# CITY OF ALBUQUERQUE

**Re: Montgomery Complex Professional Development Center and Parking Deck  
Erosion and Sediment Control Plan  
Engineer's Stamp Date 12-21-16 (G18E04f8)**

<b>WILSON &amp; COMPANY</b>	
CITY OF ALBUQUERQUE MUNICIPAL DEVELOPMENT DEPARTMENT ENGINEERING DEVELOPMENT DIVISION	
TITLE: MONTGOMERY COMPLEX EROSION CONTROL PLAN	
Design Review Committee	City Engineer Approval
City Project No. 772071	Zone Map No. G-18
Sheet 9	Of 17

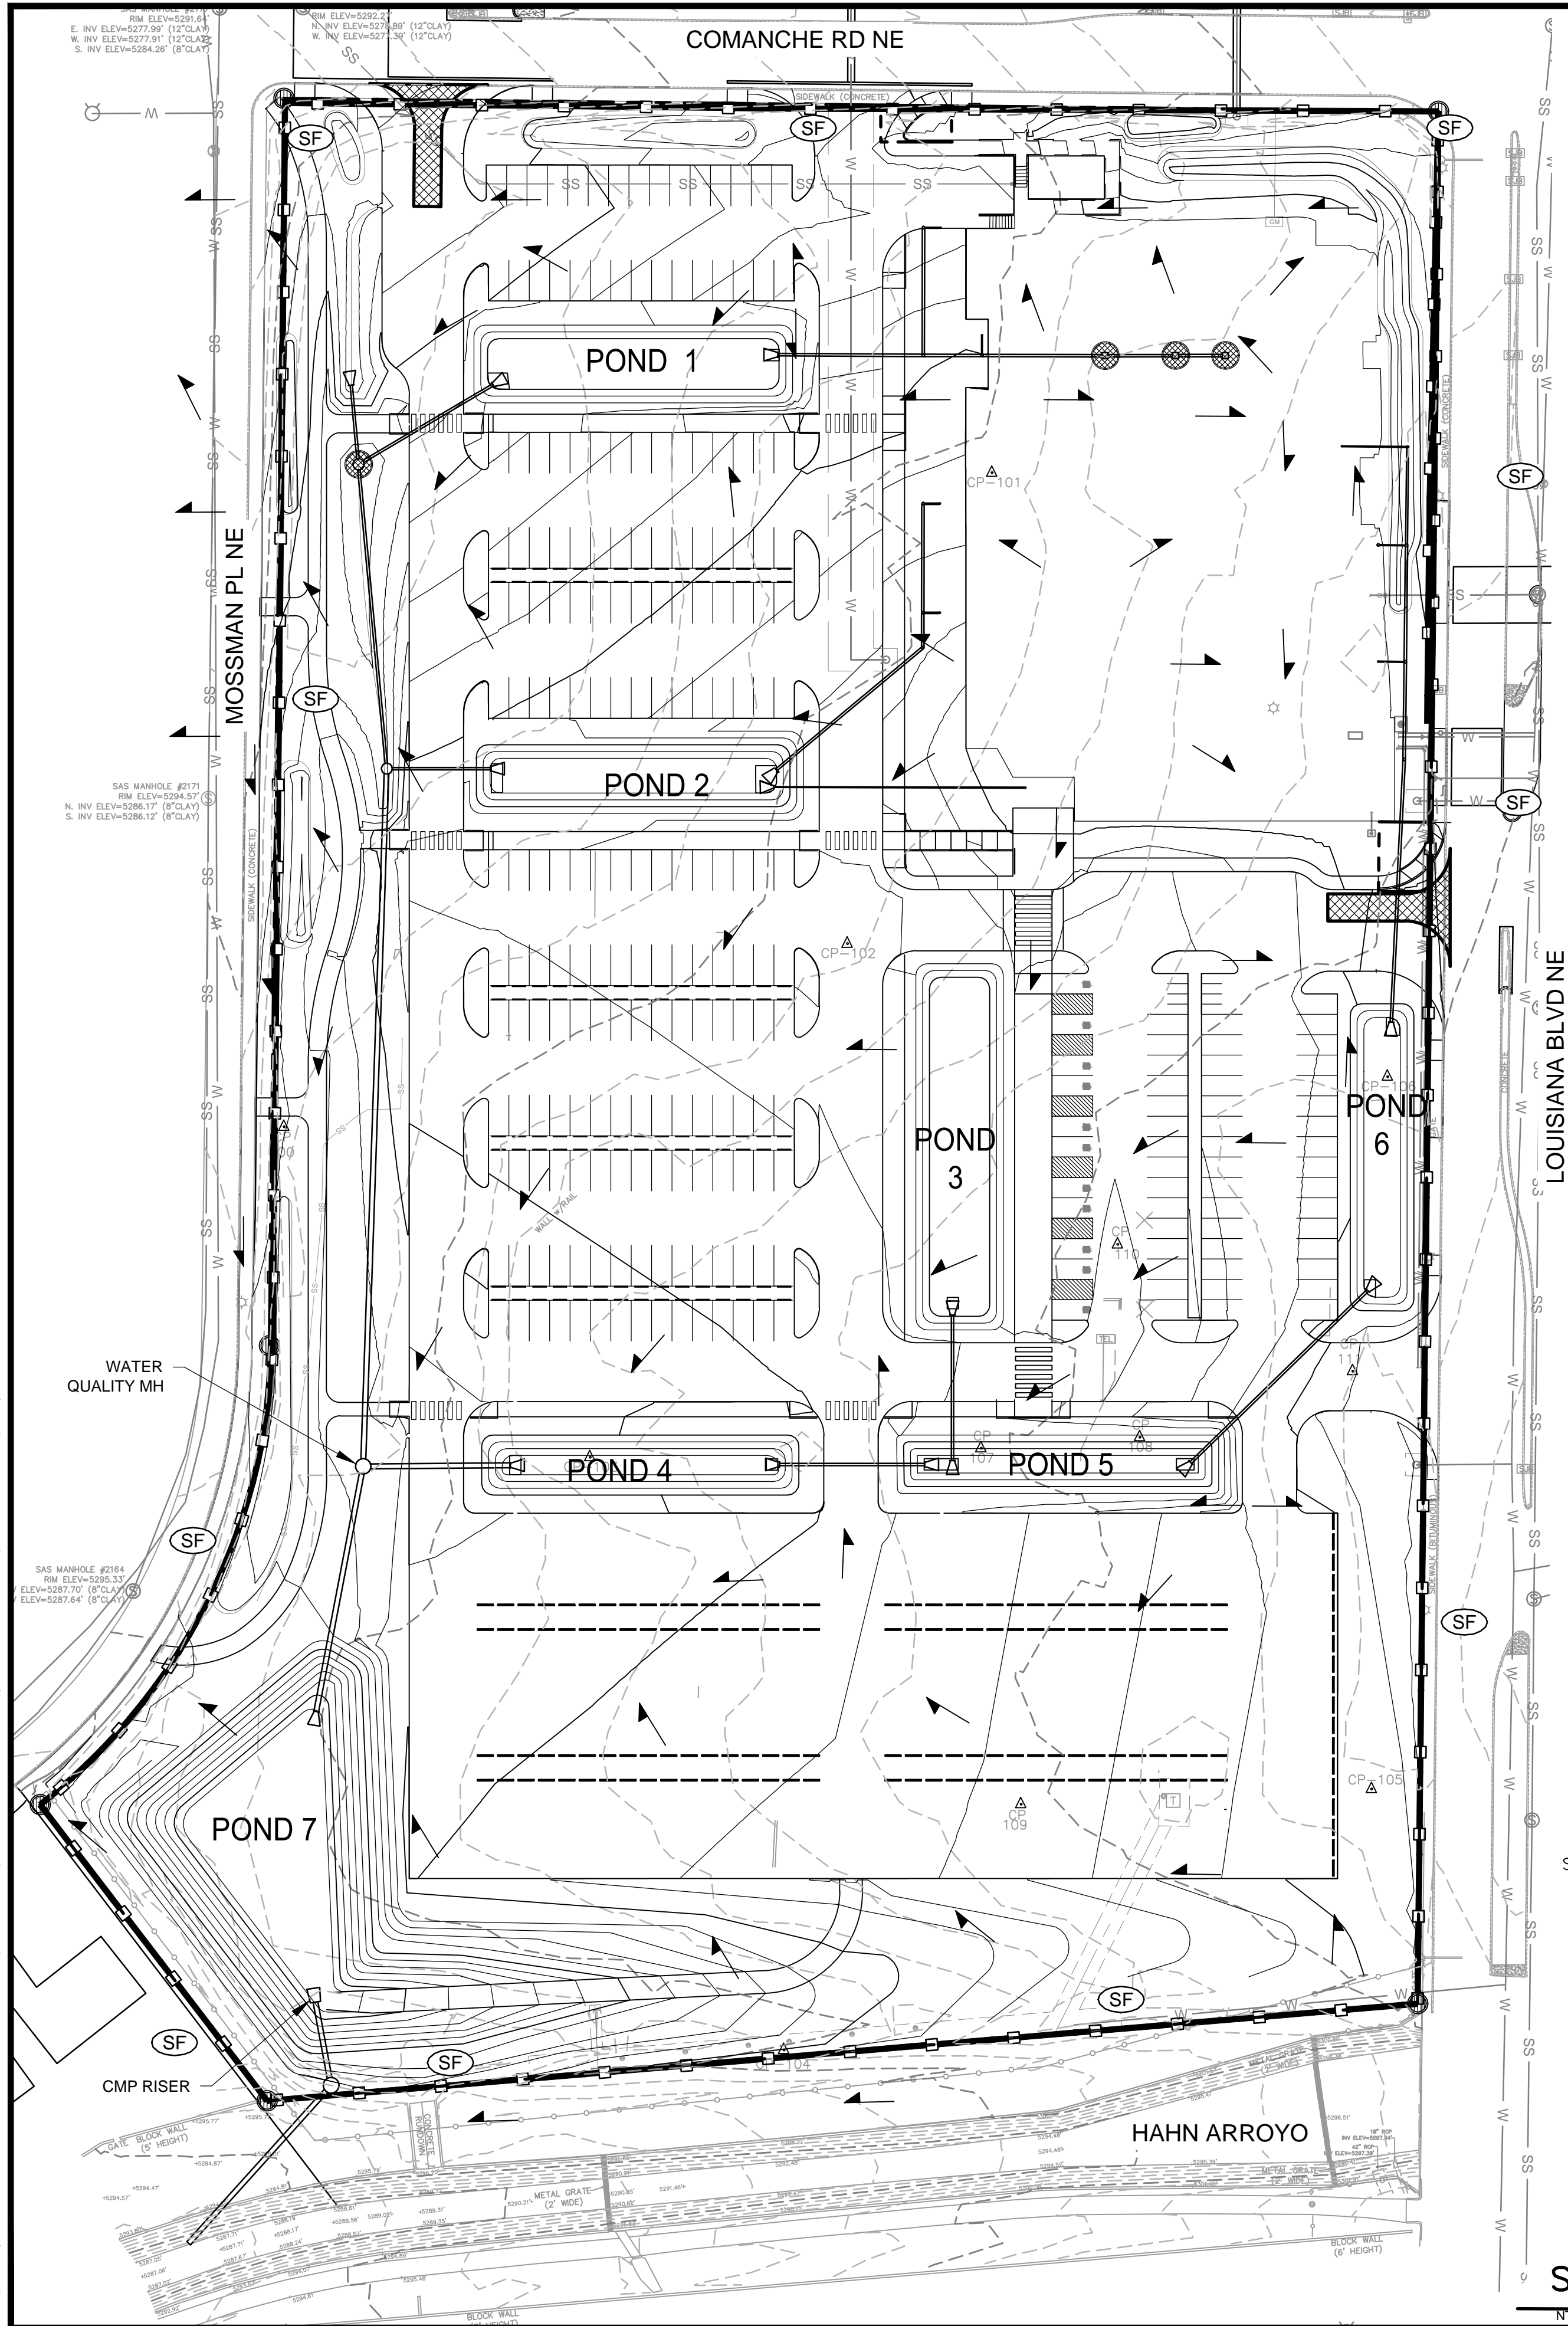
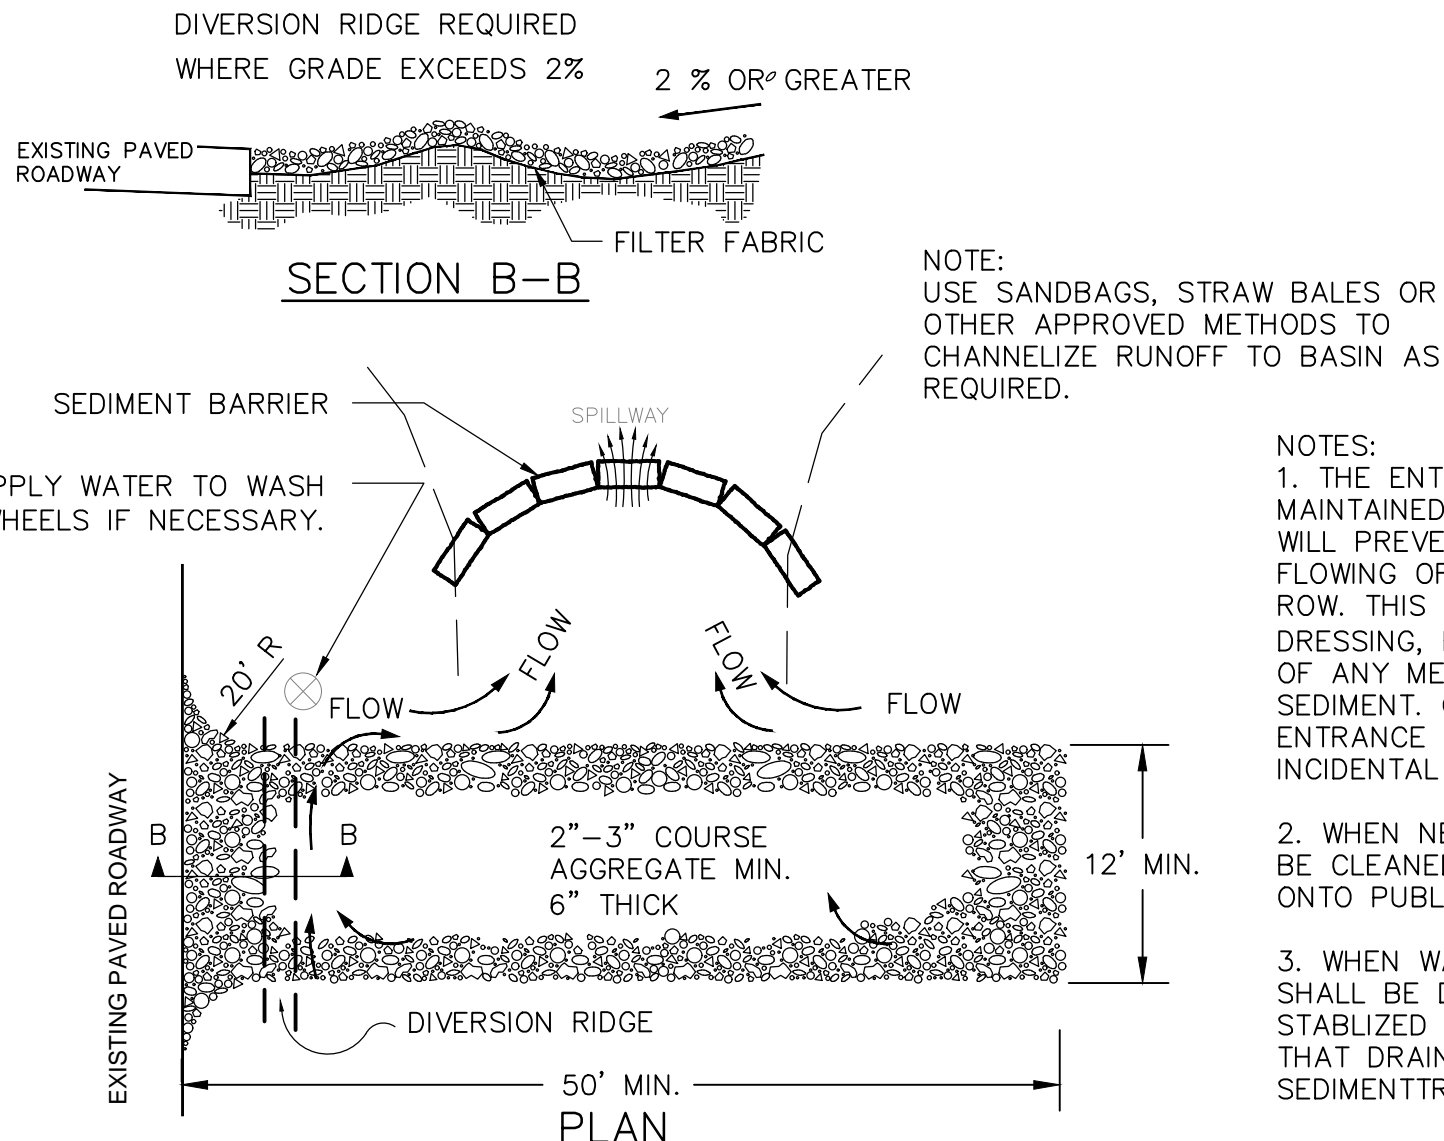
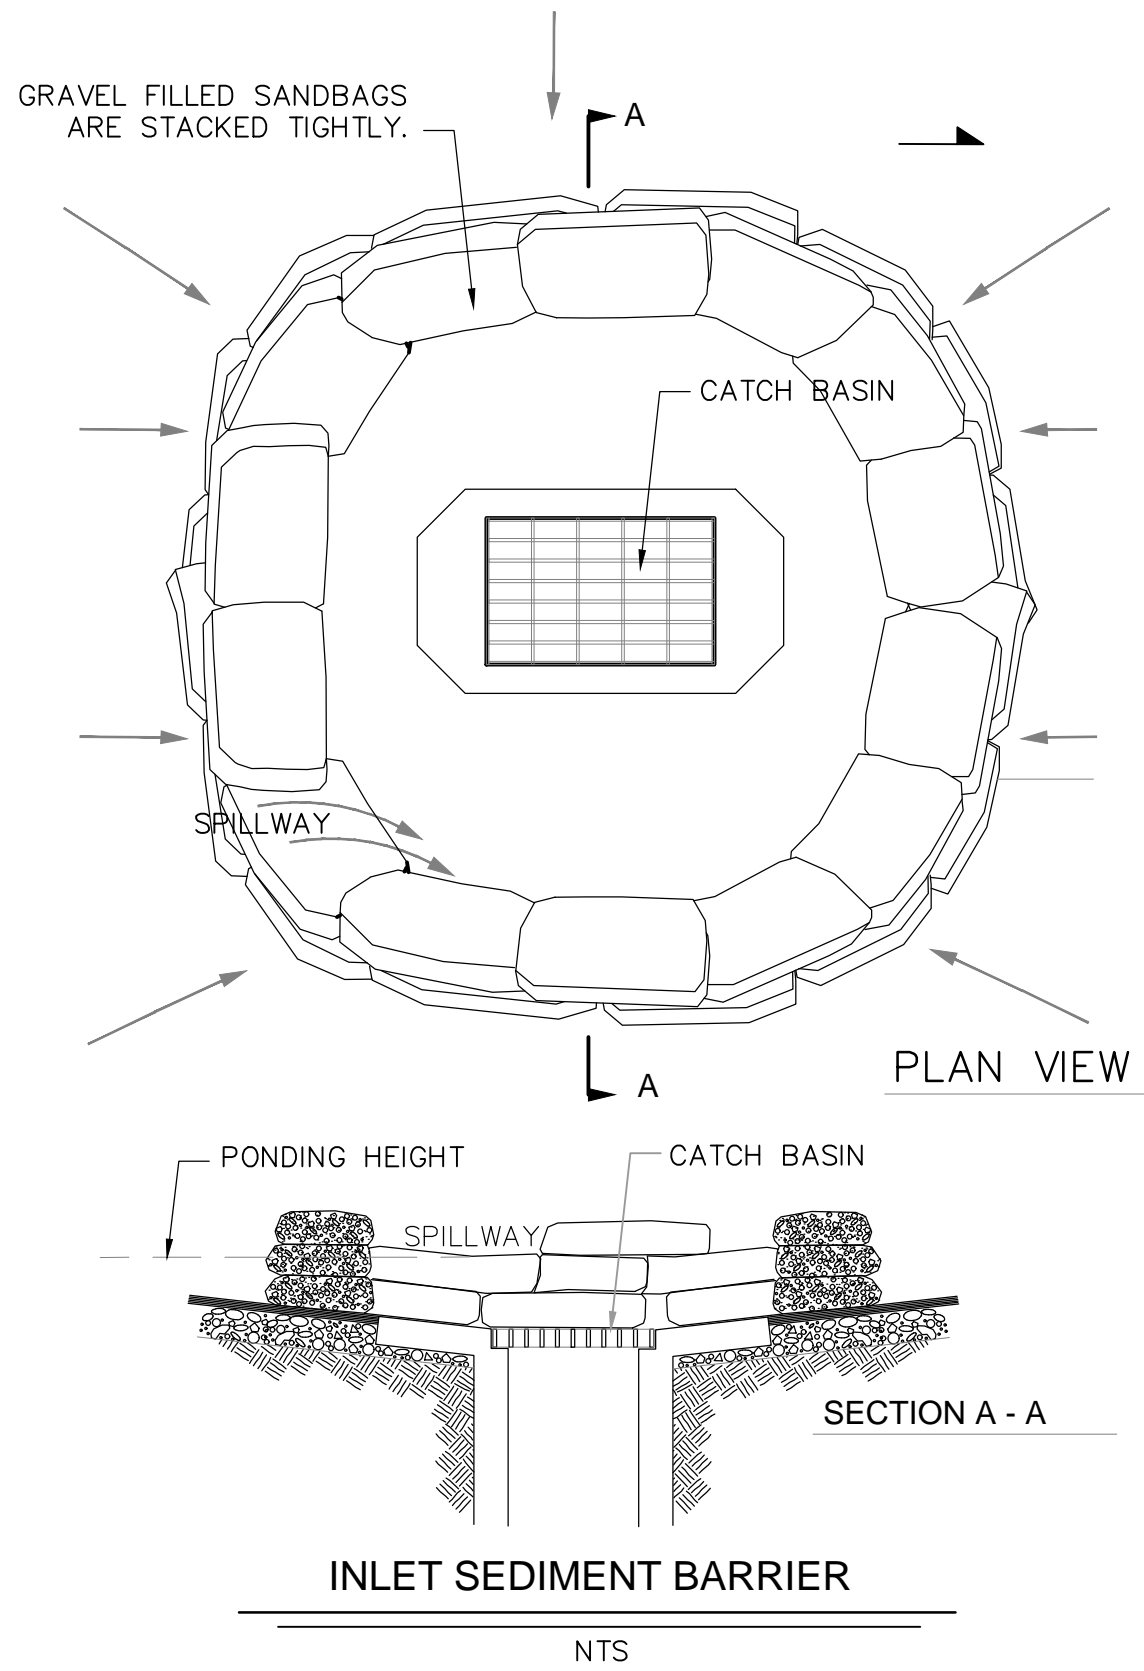
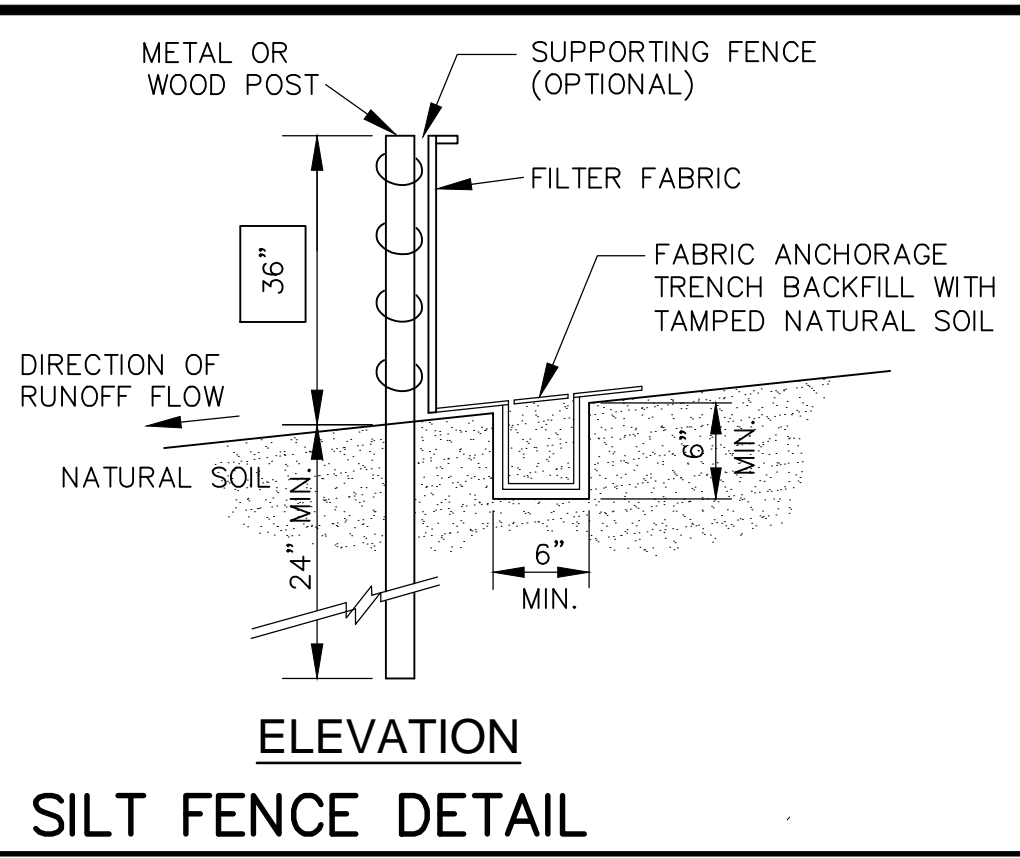
1. The disturbed limits of the ESC plan don't match the grading plan, stamp date 4-19-17.
2. Proposed grades on the east side of Mossman Pl. are above top of curb. Provide a sediment BMP.

3. Provide a BMP for the utility cuts in Comanche Blvd. The excavated soil can be piled uphill from the cut or a wattle/filter sock can be placed at the toe of the stockpile.

4. Please add a note "When doing work in the City ROW (e.g. sidewalk, drive pads, utilities, etc...) prevent dirt from getting into the street. If dirt is present in the street, the street should be swept at the end of each day or during the day if rain is imminent or if the contractor induces water into the street."

5. Provide inlet protection for the inlet in the pond in the southwest corner.
6. The plan proposes silt fence across the stabilized entrance(s).
7. The silt fence detail shows the bury trench offset from the vertical alignment of the fence. This will create slack and is atypical for silt fence installation.

8. The silt fence detail should specify the size of wood posts and type of metal posts. Minimum size for wood posts is 1.5" x 1.5 inch. Small ones get broken in the wind. Metal posts are to be "T" or "U" shaped.

9. If proposing a channel penetration, provide a BMP. Consider a note to not stockpile soil in the channel.
